CITY OF ALBUQUERQUE

**Re: Lot 11 Block 8 SAD 228
Volcano Cliffs Subdivision Unit 22
6316 Canavio Rd. NW
Grading and Drainage Plan
Engineers Stamp Date 1/20/2022 (D10D003E11)
Pad Certification Date 3/21/2022
CO Certification Date 1/18/2023**

Based on the Certification received 1/19/2023, the site cannot be accepted for release of Certificate of Occupancy by Hydrology until the following comments are addressed.

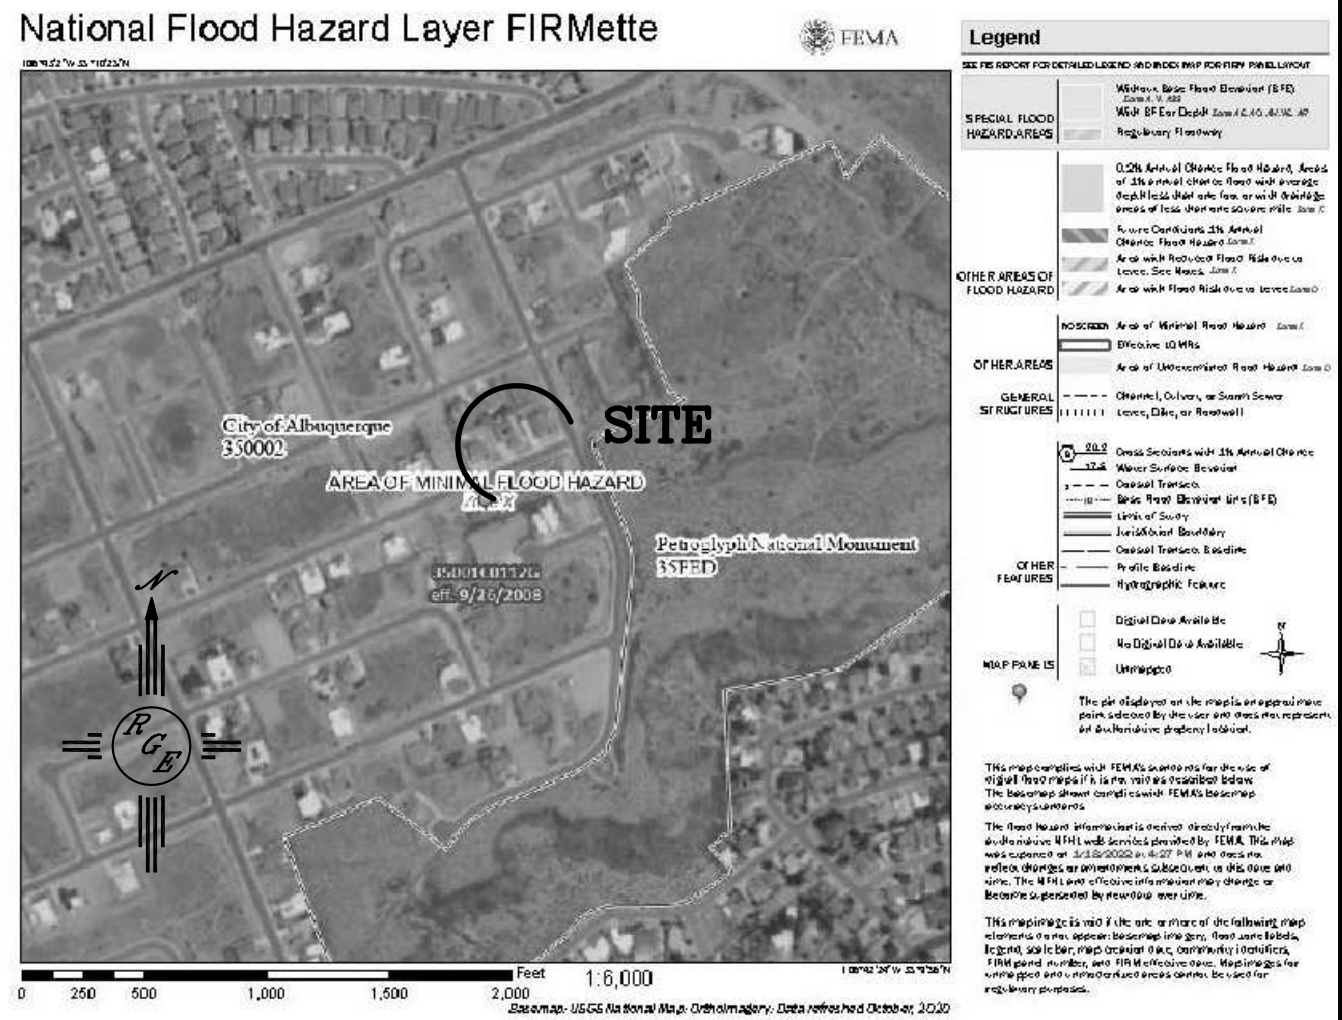
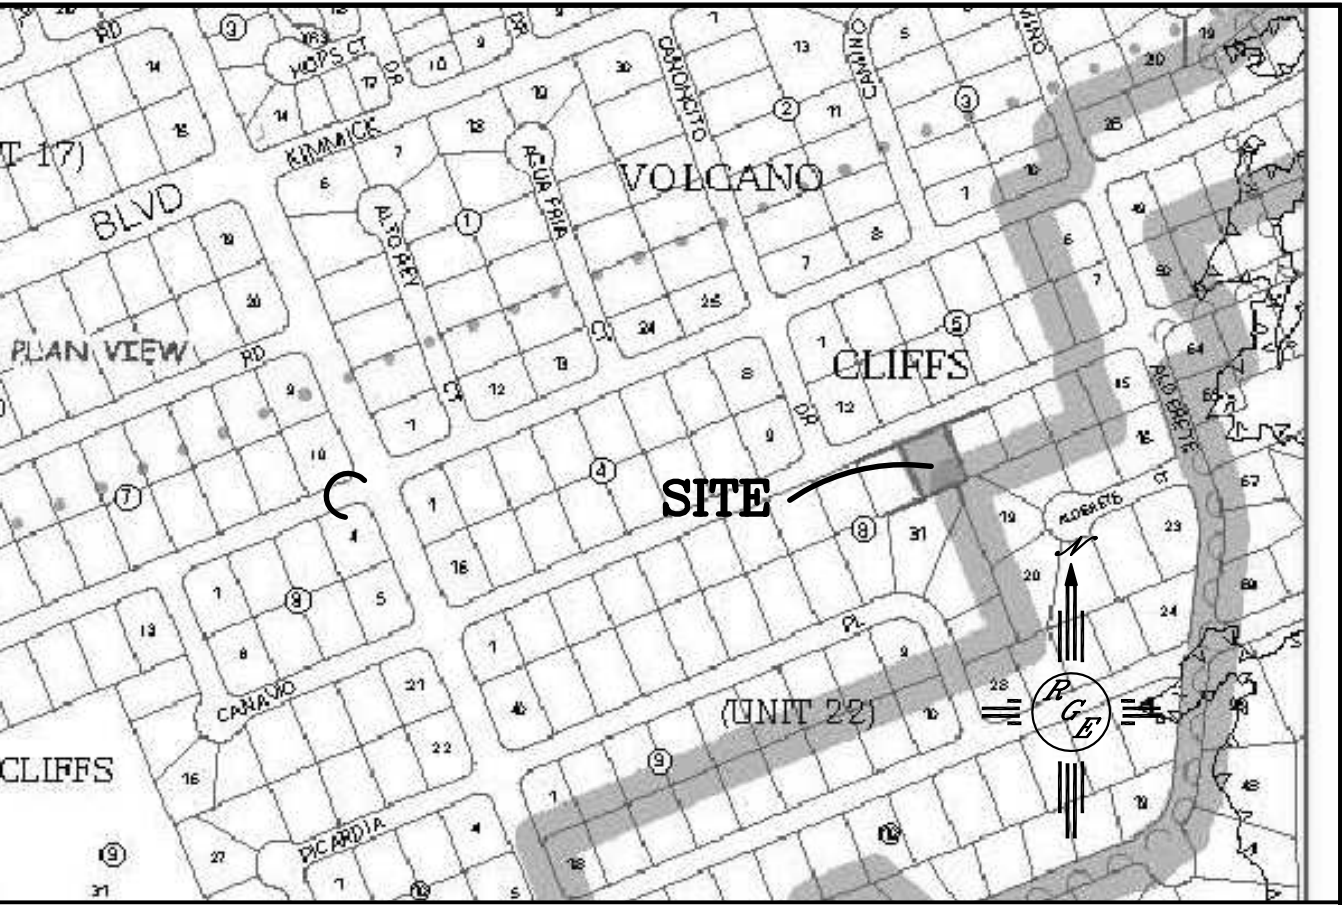
- All ponding areas and swales need to have gravel in place.
